Appeal NO: PL 302769-18

*Third Party Submission to Referral –
ABP-302769-18
(PA Reg Ref: P/DC/3/14/18)*

"Whether the conversion of a ground floor office space for use as a two-bedroom apartment is or is not development or is or is not exempted development".

*Ti Choinn, Gleann na Ri, Murrough, Galway
City*

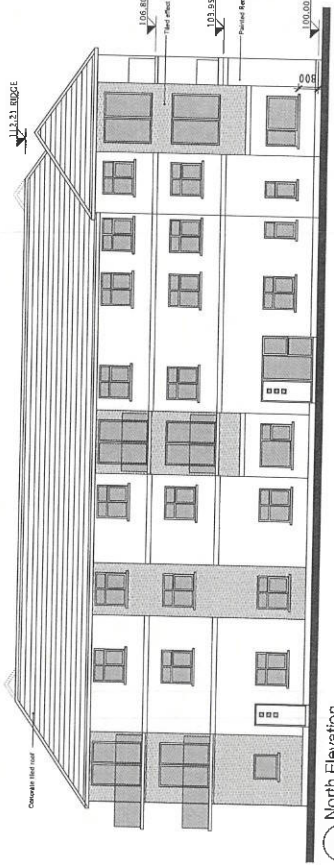
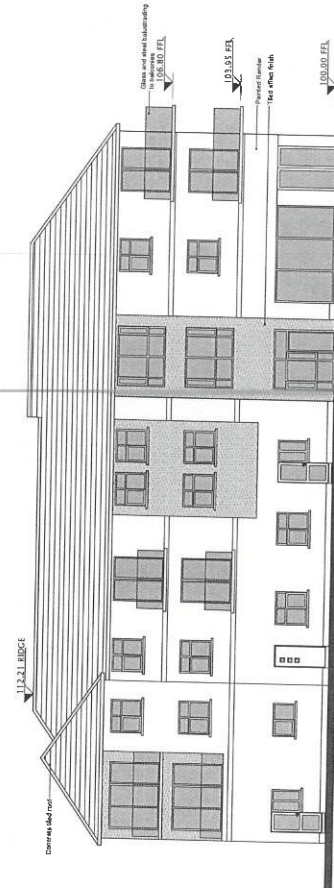
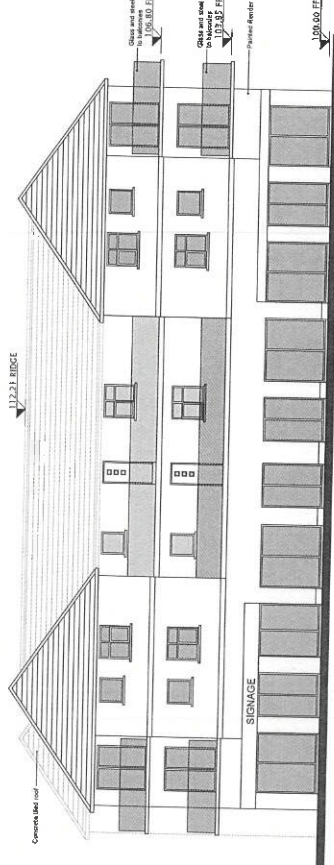
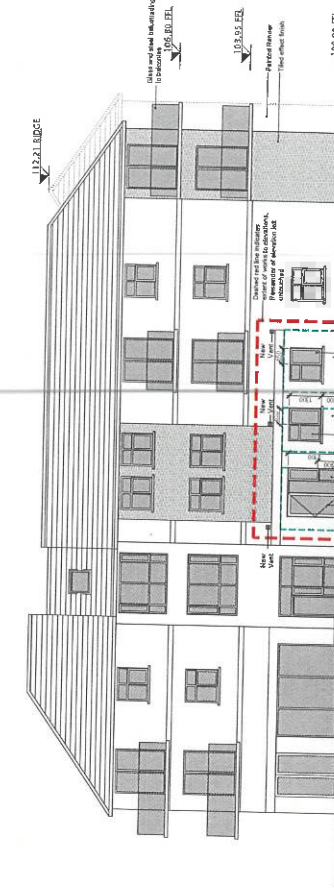
<p>6(d)(i) <i>"The development is commenced and completed during the relevant period."</i></p>	<p>This is subject to compliance with the other criteria.</p>
<p>6(d)(ii) <i>"Subject to sub-paragraph (iii), any related works, including works as may be required to comply with sub-paragraph (vii), shall affect only the interior of the structure and shall not materially affect the external appearance of the structure so as to render its appearance inconsistent with the character of the structure or of neighbouring structures."</i></p>	<p>It should be noted that the applicant has now proceeded with the "proposed works" and the external changes are now complete (See Figure 1 above). The south east elevation is the main elevation facing onto the access road/public realm. In time this thoroughfare could potentially serve the extensive Murrrough Local Area Plan area (LAP), further to the south. The reduction in the glazing along the subject unit is significant, and is inconsistent with the frontage of the adjoining creche, and will materially affect the external appearance of the structure.</p>

<p>6(d)(iii) <i>"Any related works for the alteration of existing ground floor shop fronts shall be consistent with the fenestration details and architectural and streetscape character of the remainder of the structure or of neighbouring structures."</i></p>	<p>Again the alteration of the existing "shopfront" is considered to be inconsistent with the character of the remainder of the structure (especially the creche unit).</p>

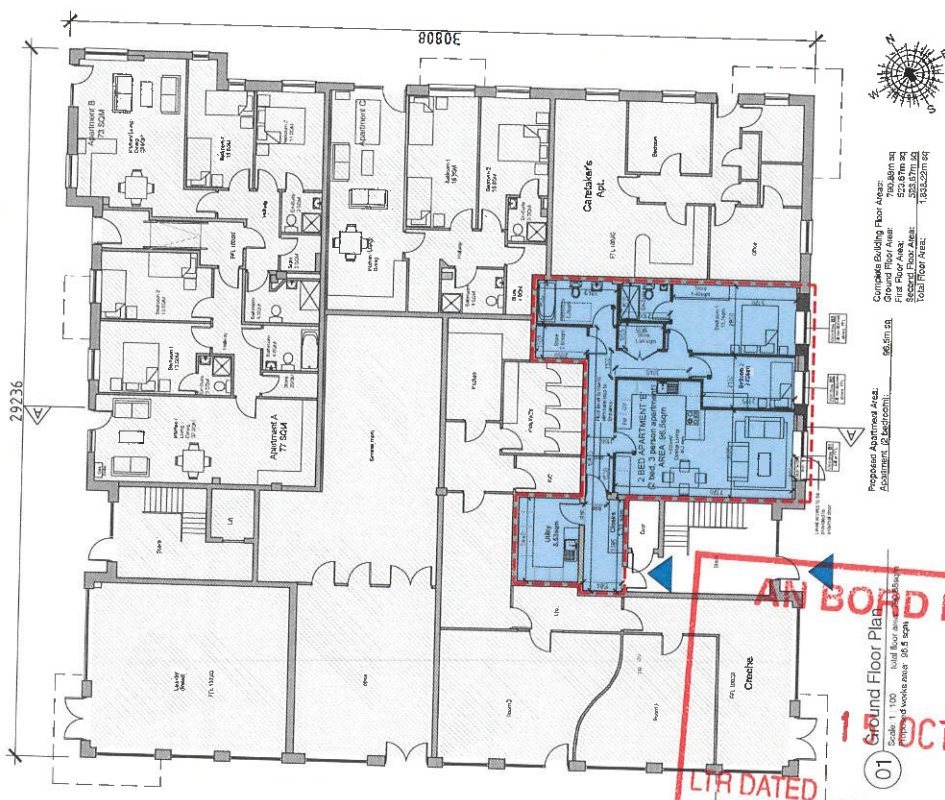
I wish to make you aware that the proposed drawings ignore the existence of the Gleann Na Ri communications room that contains the essential common area services of the estate. The Gleann Na Ri estate comprises of fourteen apartment complexes and the entire estate's CCTV cables, CCTV equipment, telephone and internet lines and patch panels, fibre optic cables, gate communication cables and all of the fire alarms cabling and connections are housed within this area. I have outlined the location of these services on the attached drawing. It is not possible for the management company to operate without having access to these essential services located in this area.
